Our reference: EF13/3893, DOC16/52234-02
Contact: John Goodwin

SSD 7311 – TARONGA ZOO RESEARCH AND EDUCATION FACILITY EIS

ATTACHMENT A

TARONGA ZOO RESEARCH AND EDUCATION FACILITIES

Figure 1 - Site Location and Noise Measurement Possessions

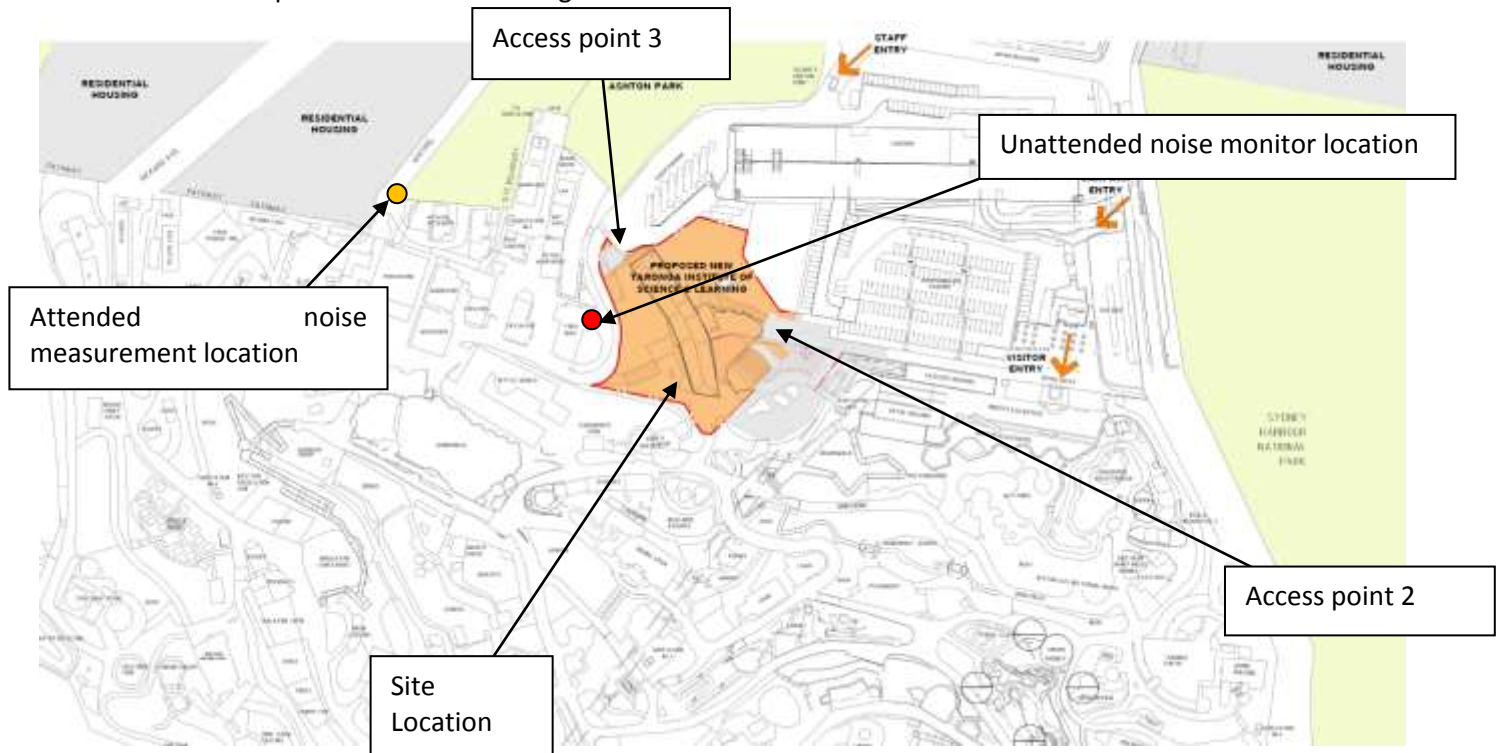
- (i) Figure 1 to EIS Appendix N indicates that unattended noise monitoring for the purpose of establishing background noise levels was not undertaken in the appropriate location;
- (ii) Section 3.2 of EIS Appendix N states that background noise level monitoring was undertaken between 23 September 2015 and 29 September 2015 but the noise monitoring graphs accompanying Appendix N are labelled 23 to 29 October 2015;
- (iii) Bureau of Meteorology (BoM) observations for both periods referred to in preceding paragraph (ii), indicate that on several days the prevailing meteorological conditions were unsuitable for noise monitoring to establish background noise levels;

Figure 1 to EIS appendix N indicates that the unattended noise monitoring required to establish the background noise level was undertaken within the Zoo instead of at the location (i.e. residences) set out in Table 3.1 *Methods for determining background noise* to the INP.

The proponent be required to establish background noise levels for the locality by undertaking noise monitoring in accordance with guidance material provided in Chapter 3 to the NSW Industrial Noise Policy.

APPENDIX 1: NOISE LOGGING DATA

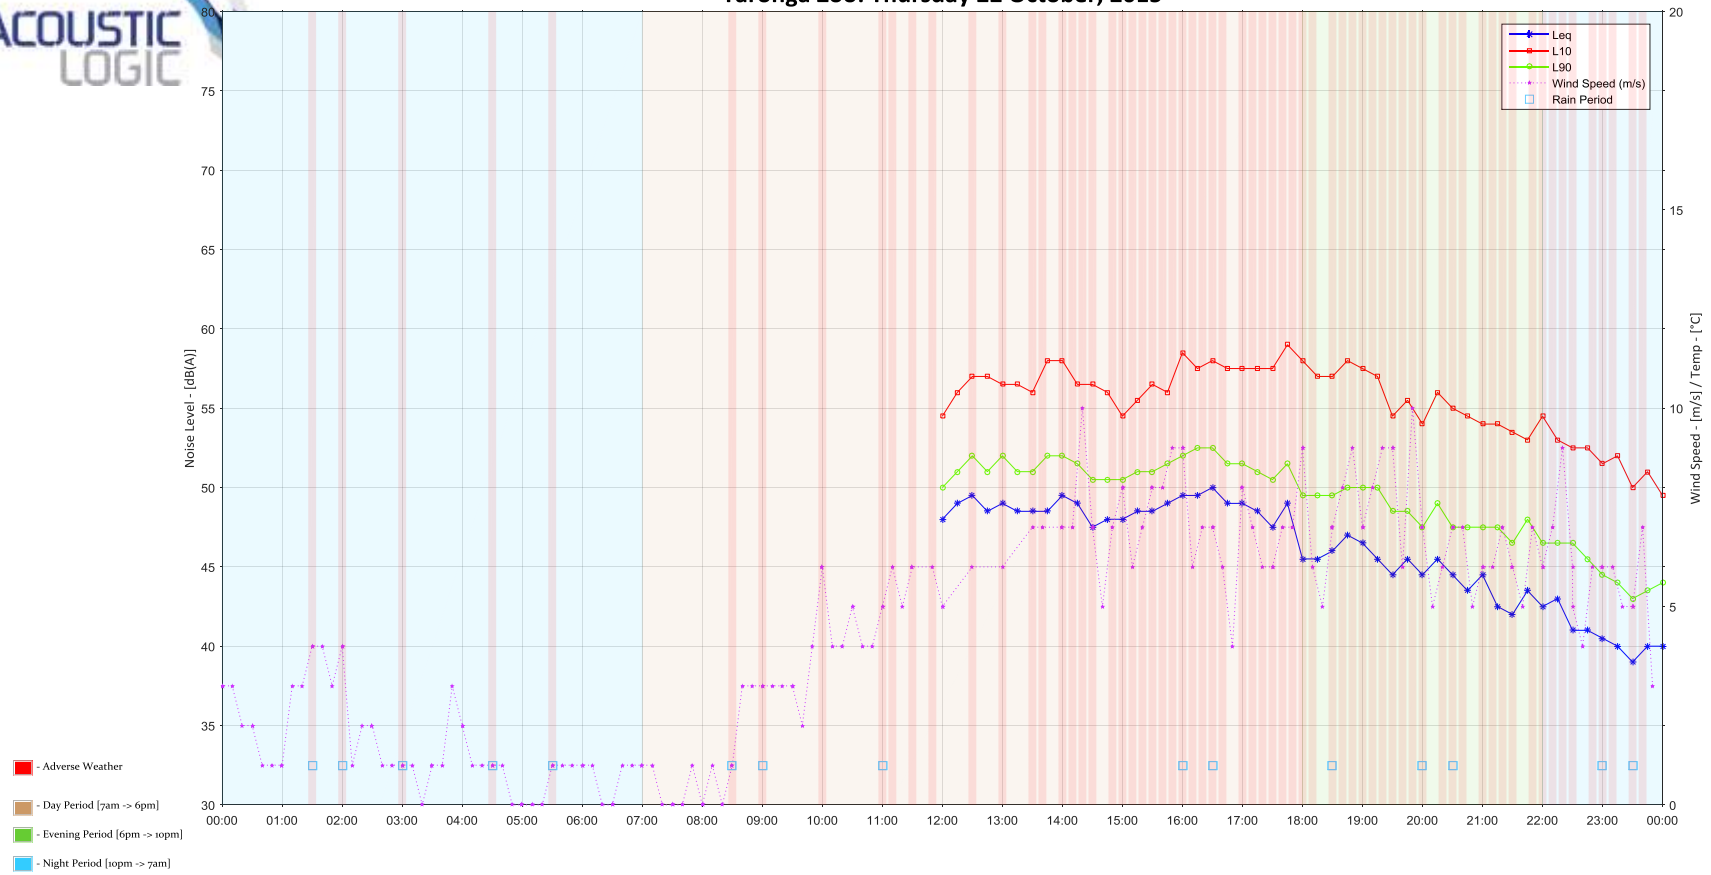
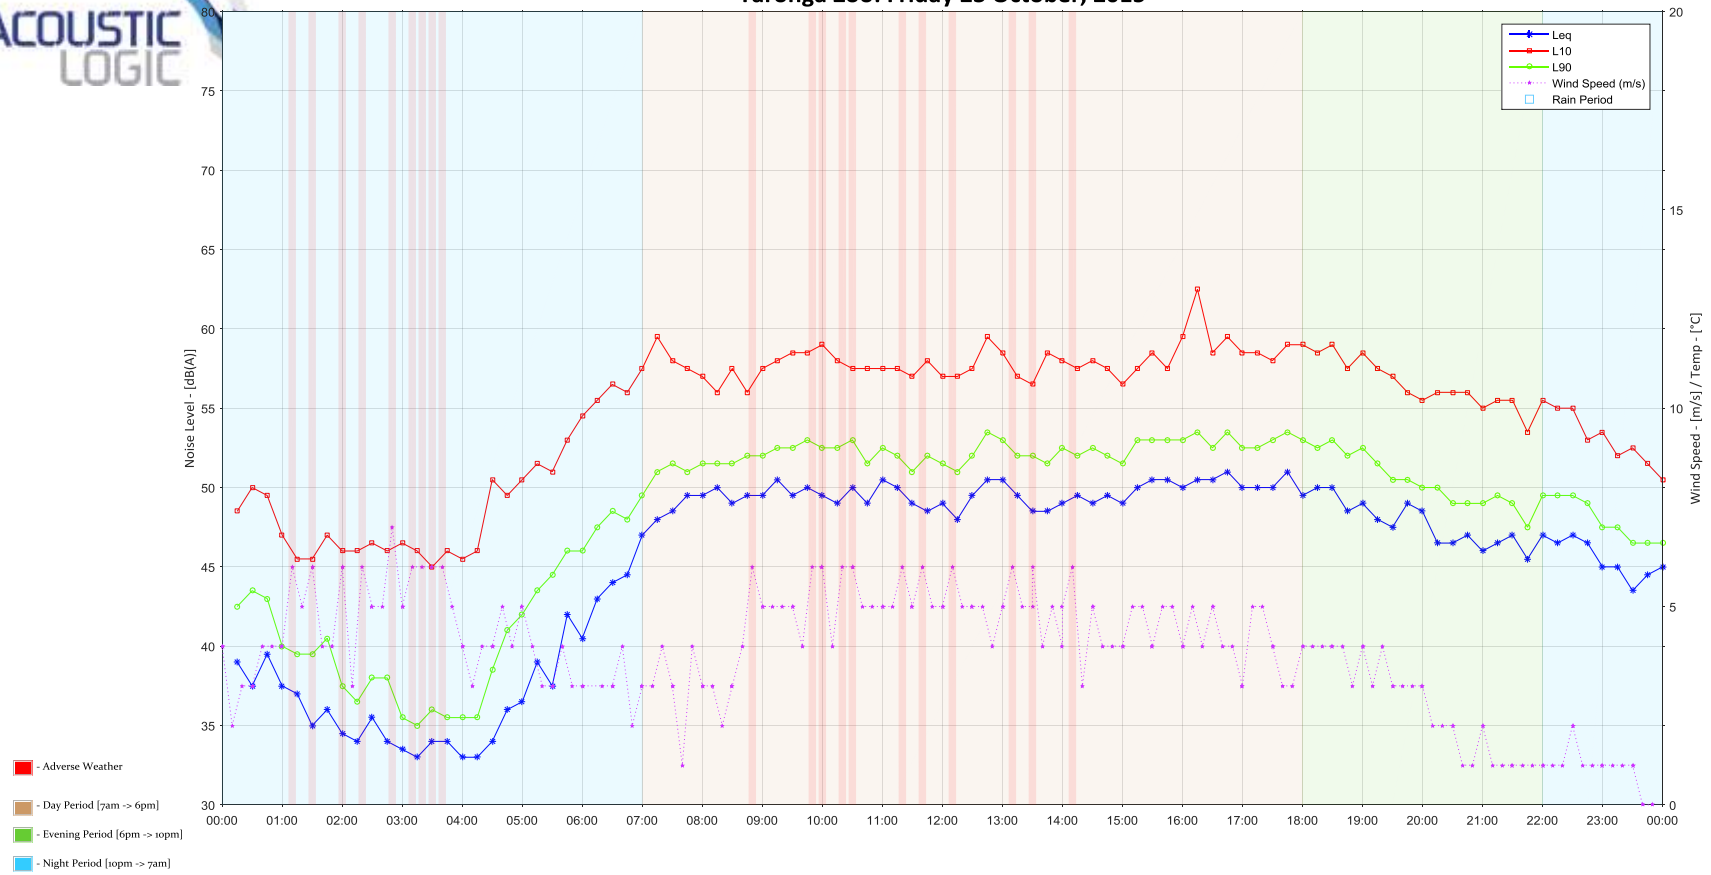
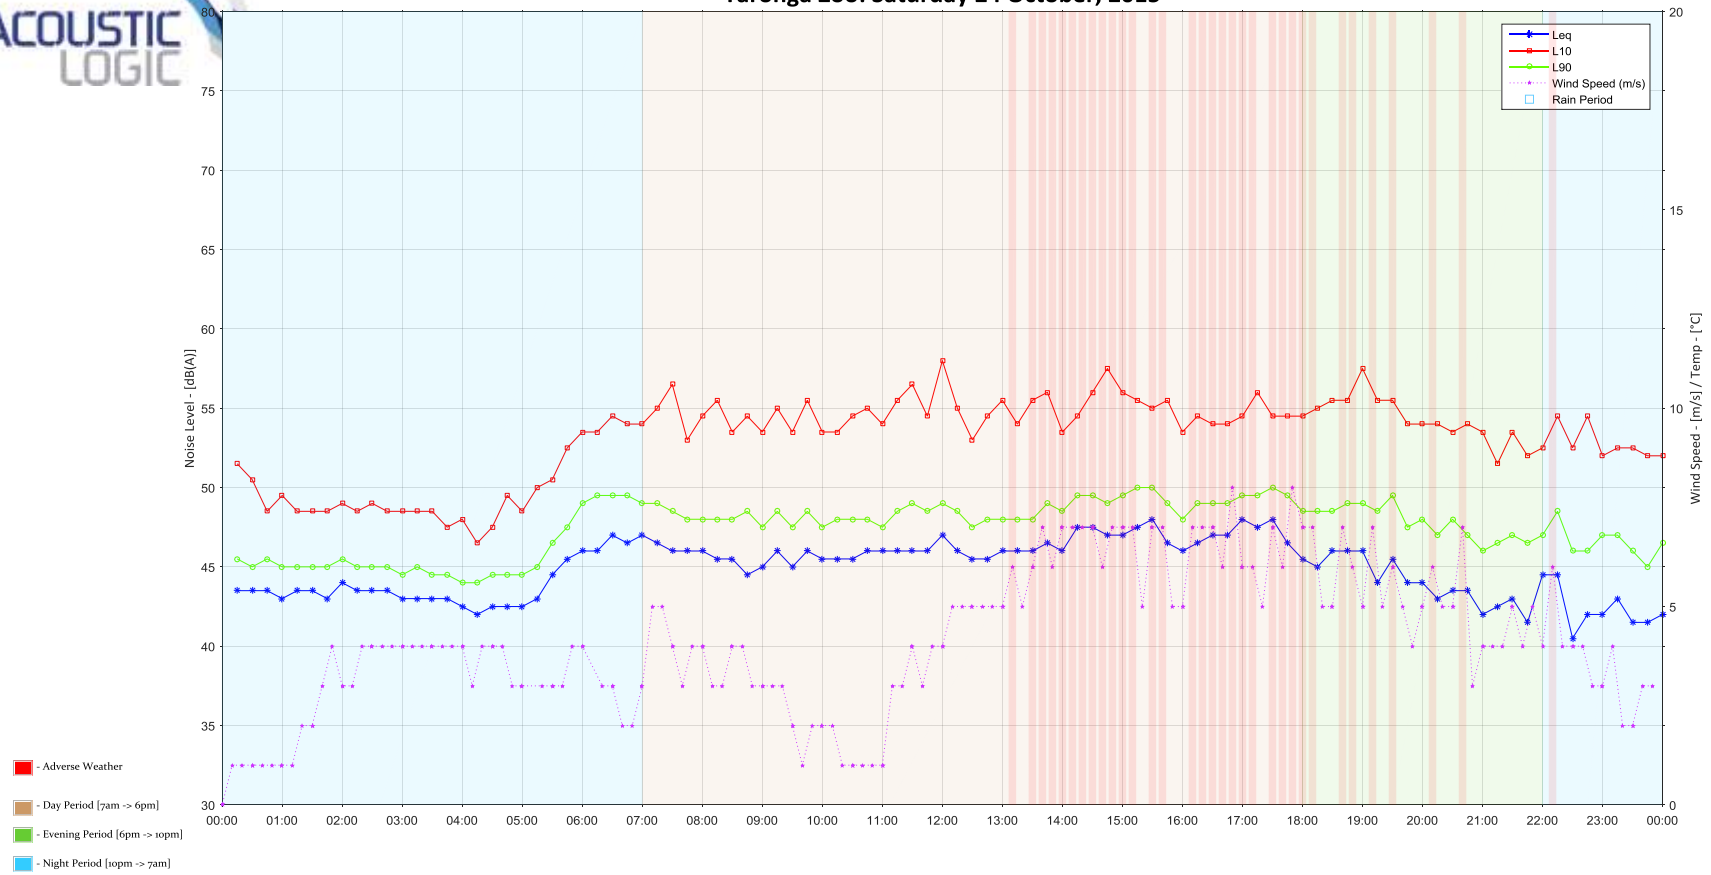
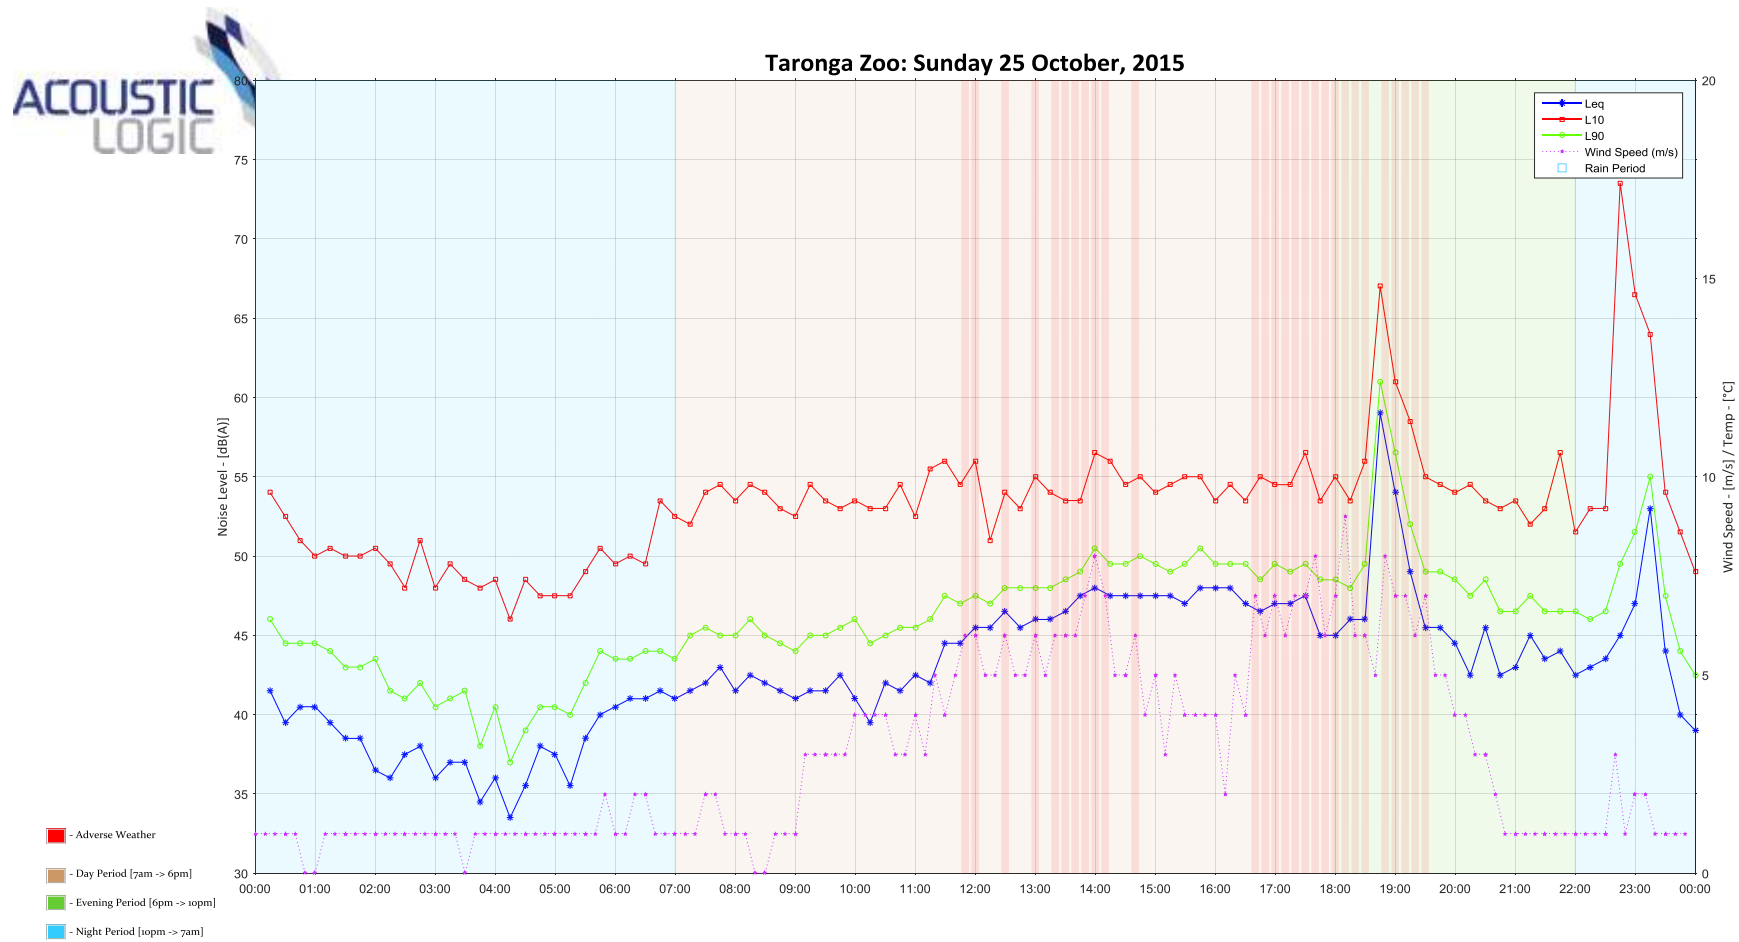
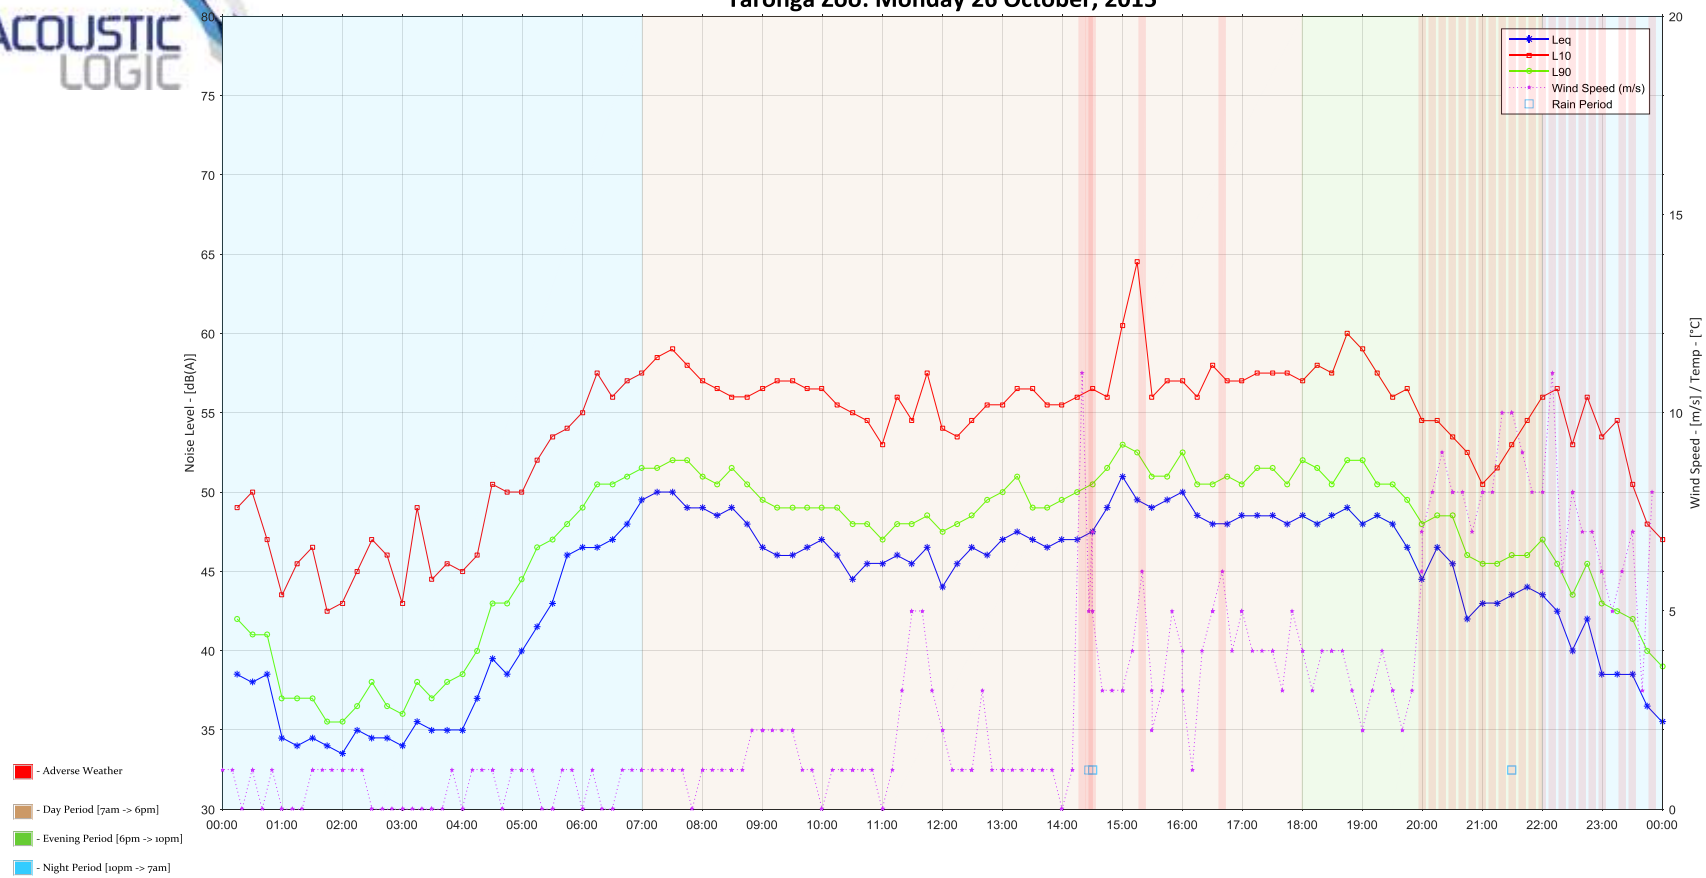
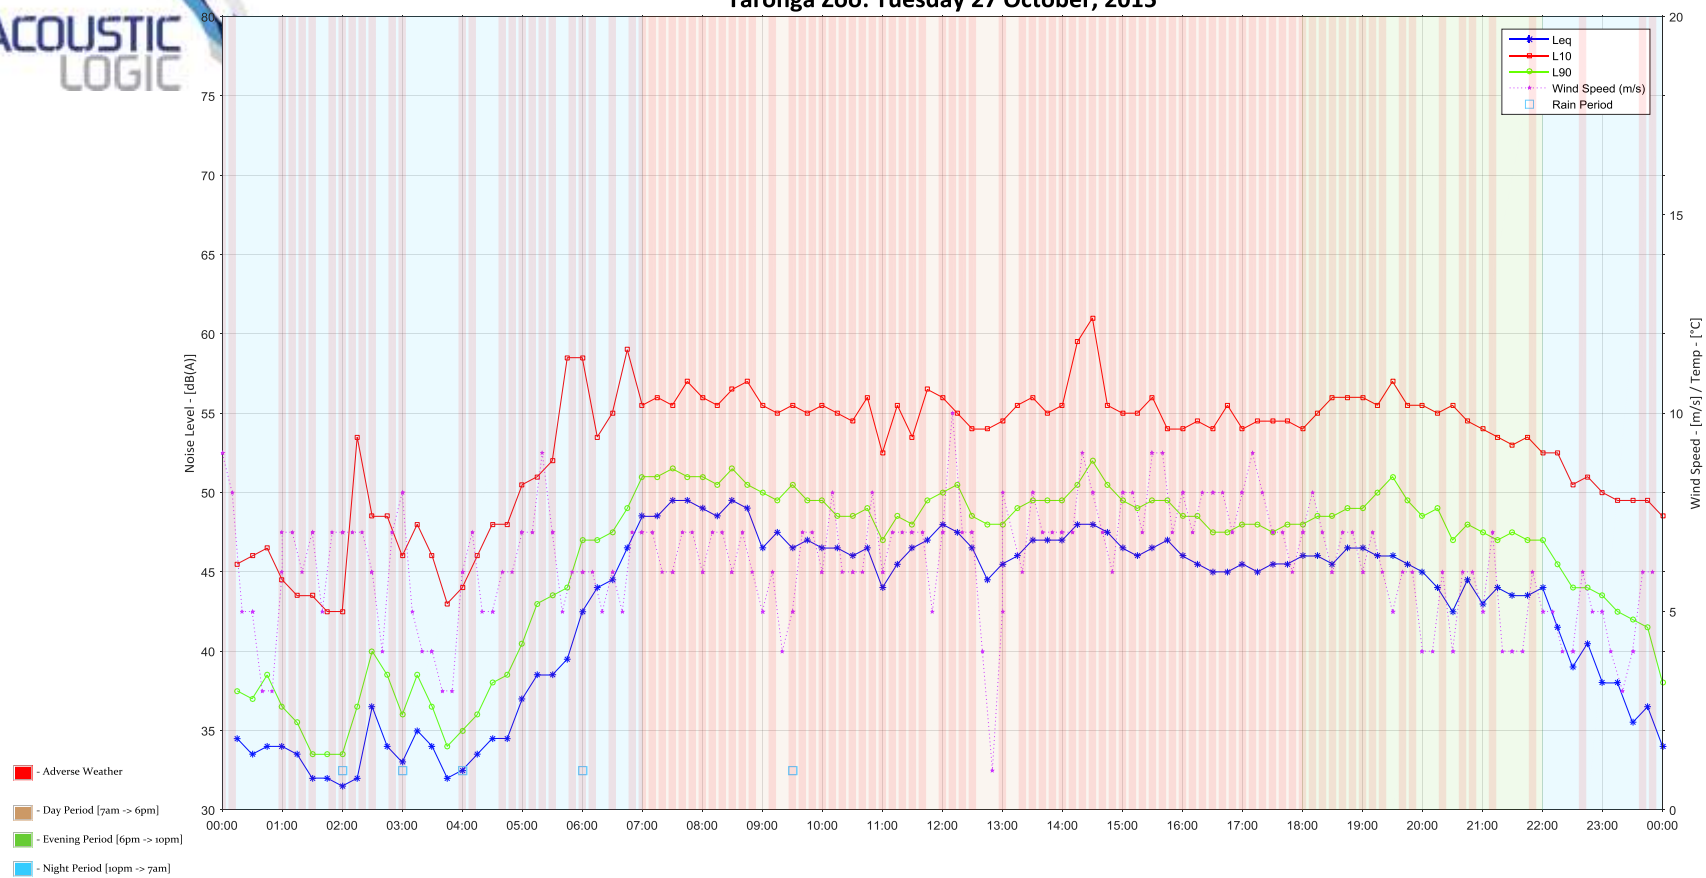
However, the EPA notes that the noise monitoring graphs attached to Appendix N are labelled 23 October 2015 to 29 October 2015. Nevertheless, on the assumption that the noise monitoring was actually undertaken in October 2015 rather than September, rain and wind speeds exceeding 18 kilometres per hour were also observed on several days between 23 and 29 October 2015.

EIS Appendix N does not appear to provide any justification for not excluding the weather affected noise monitoring data used to establish the measured background noise levels presented in Table 2, which data may have been conflated by unfavourable meteorological conditions.
